## DECISION DELEGATED TO HEAD OF PLANNING

**Application No:** H08-0852-25      **Applicant:** Mrs K M Baxter  
**Proposal:** Demolition of Existing Barns & Erection of 2 Dwellings  
**Location:** Belnie House Farm Buildings Belnie Lane Gosberton  
**Terminal Date:** 6th November 2025

## FRONT ELEVATION 1:100

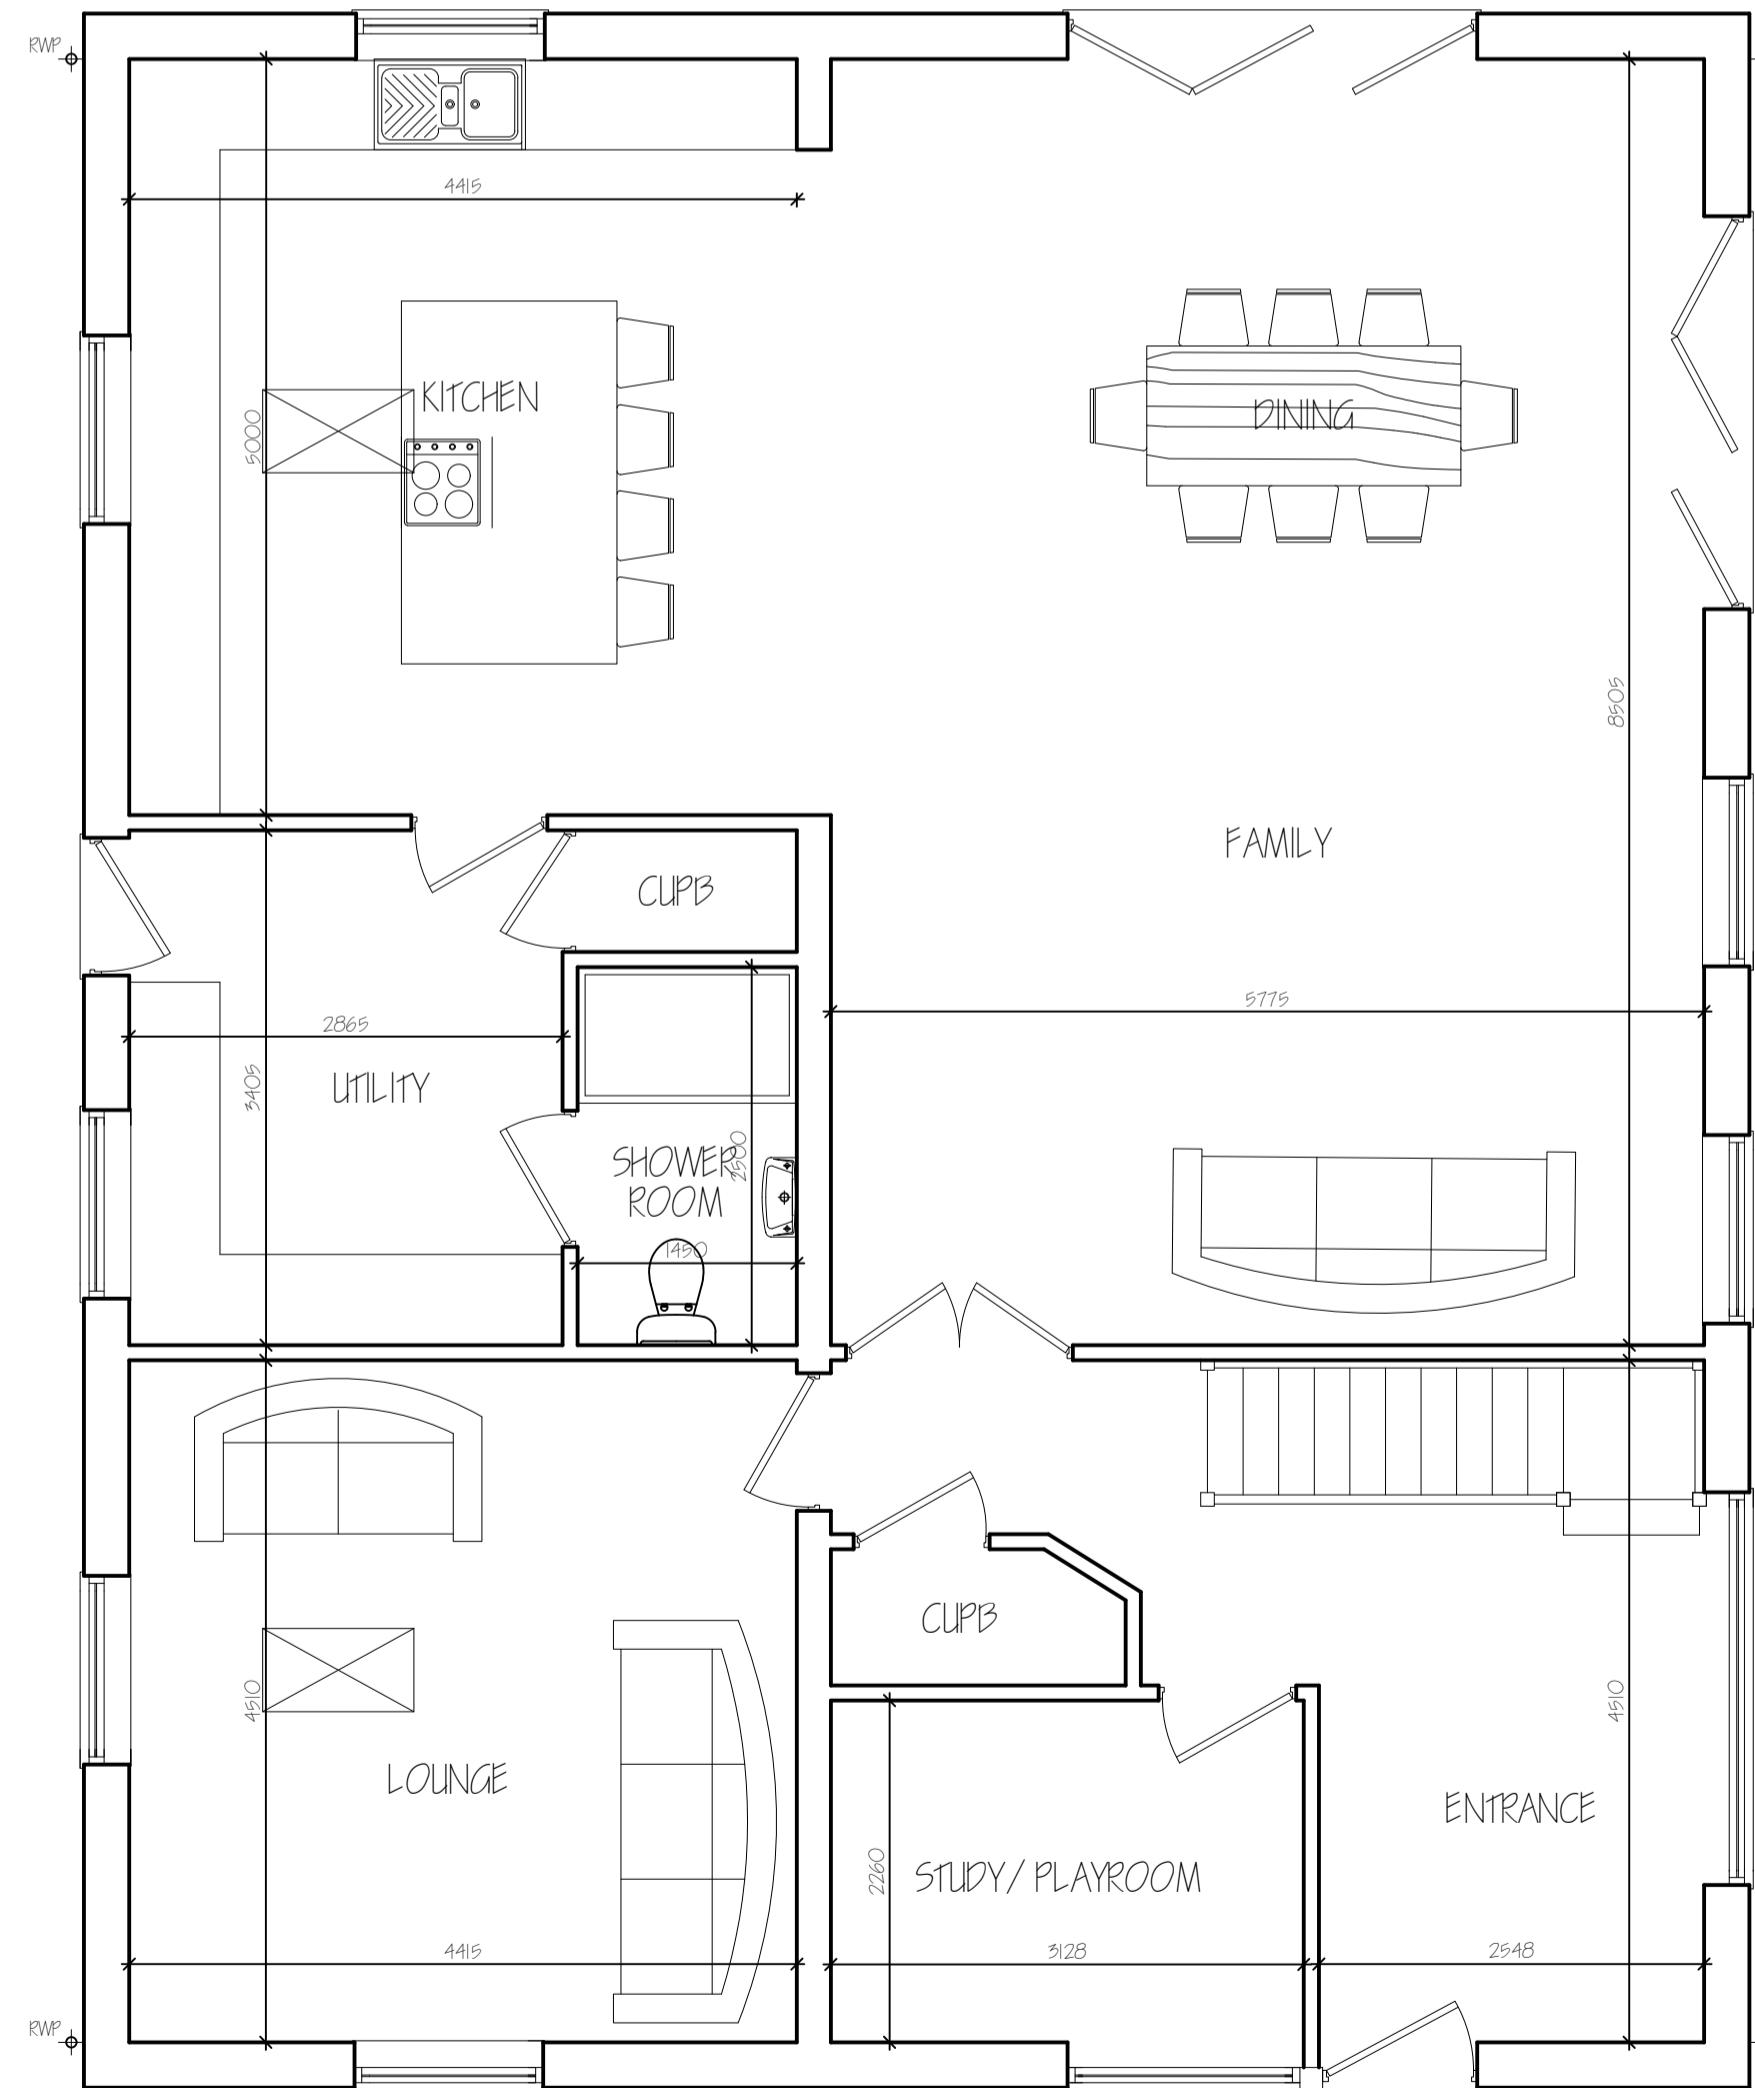
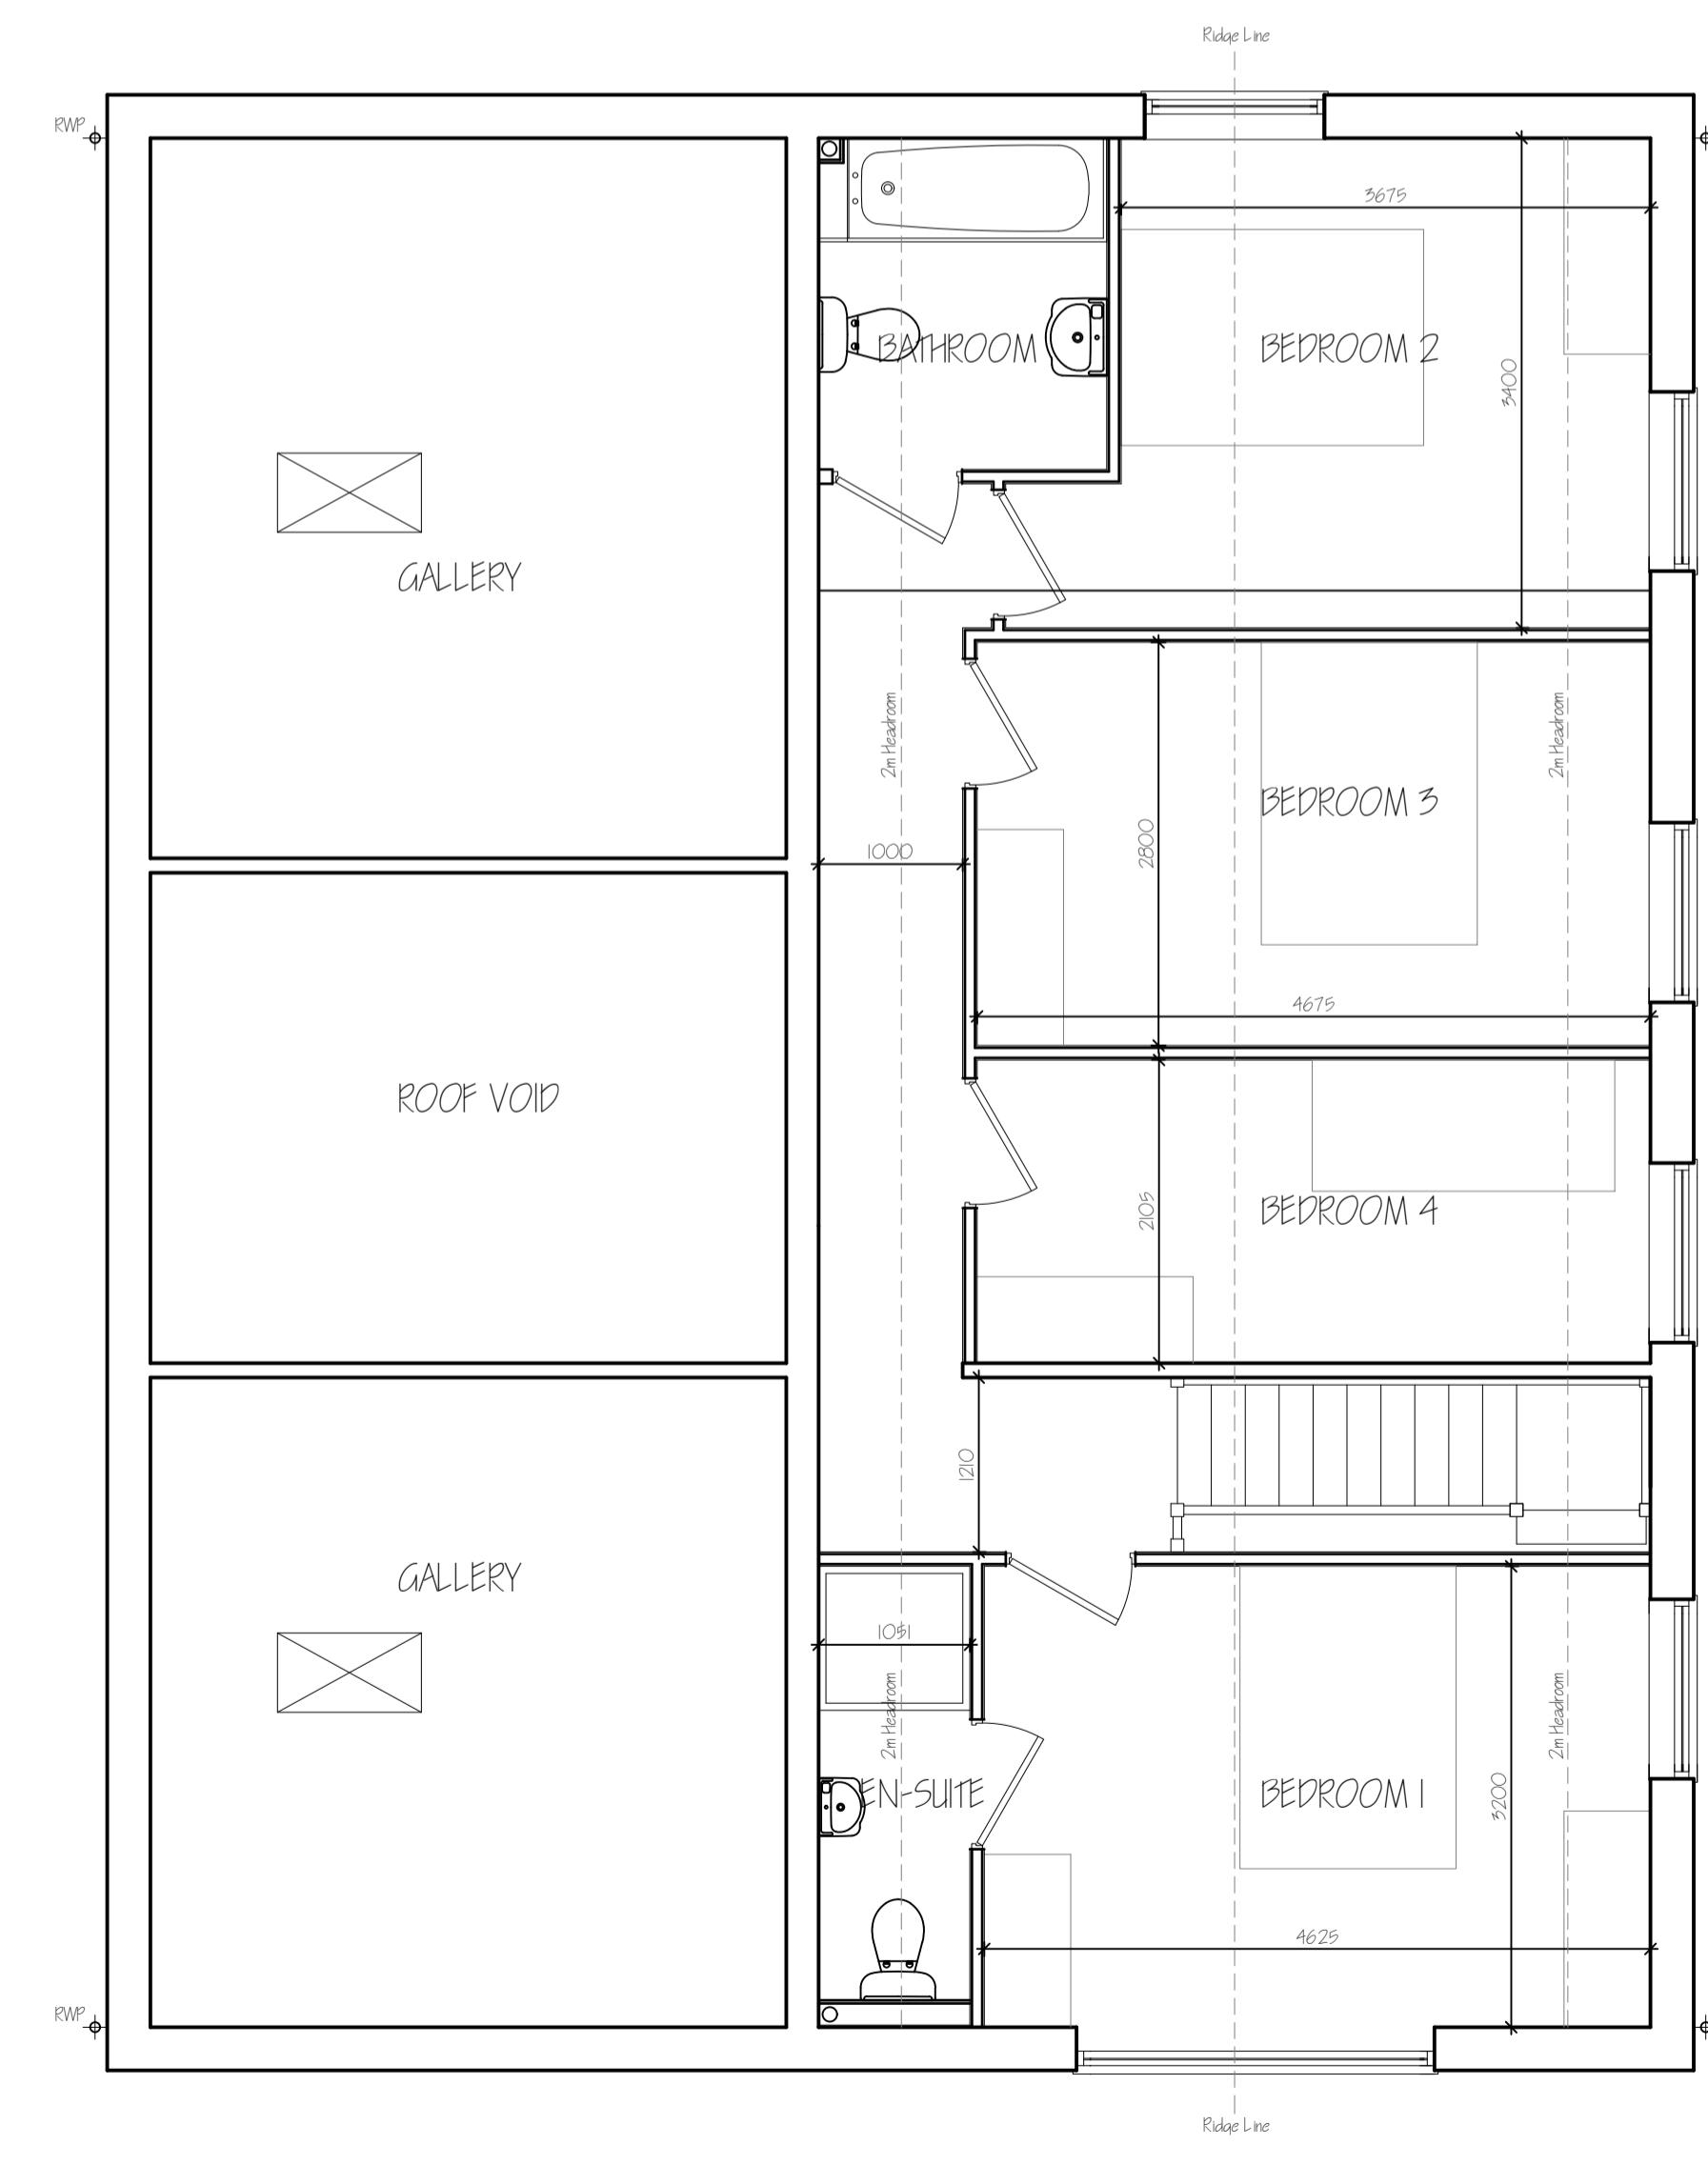
The current proposals seek to demolish the existing buildings within the site and install 2 matching dwellings. For example, both dwellings would feature a gable end roof form and a sloping roofline on the proposed side extensions. The dwellings would each measure 11m by 13.7m, and 7.1m in height up to the roof ridgelines. The proposed materials are not indicated within the submitted elevation plans; however, the application form refers to facing bricks, tiles and aluminium windows and doors.

The submitted Planning, Design and Access statement fails to justify the design rational in terms of its appropriateness to this location. Notwithstanding this, it is considered likely that the design is based on the approved barn conversion that was allowed under approval H08-0970-24. For example, both dwellings would feature a gable end roof form and a side extension with a sloping roof form. Furthermore, the approved conversion was proposed to measure 10.8m by 14m, and 6.5m in height. As such, the proposed dwellings would be of a comparable scale and feature a similar roof form to one of the approved conversions within the site. There are some key differences though such as the inclusion of new brickwork and additional windows and doors, including a large glazed element on the south-eastern elevation.

There would be approximately 13m between the proposed dwellings within the site. Various bedroom windows are proposed at the first-floor level and these windows would face towards the rear elevation of the proposed dwelling to the north-east. Whilst the bedroom windows would look onto the kitchen and lounge windows of the other dwelling, it is not considered that this would result in an adverse degree of overlooking between the plots.
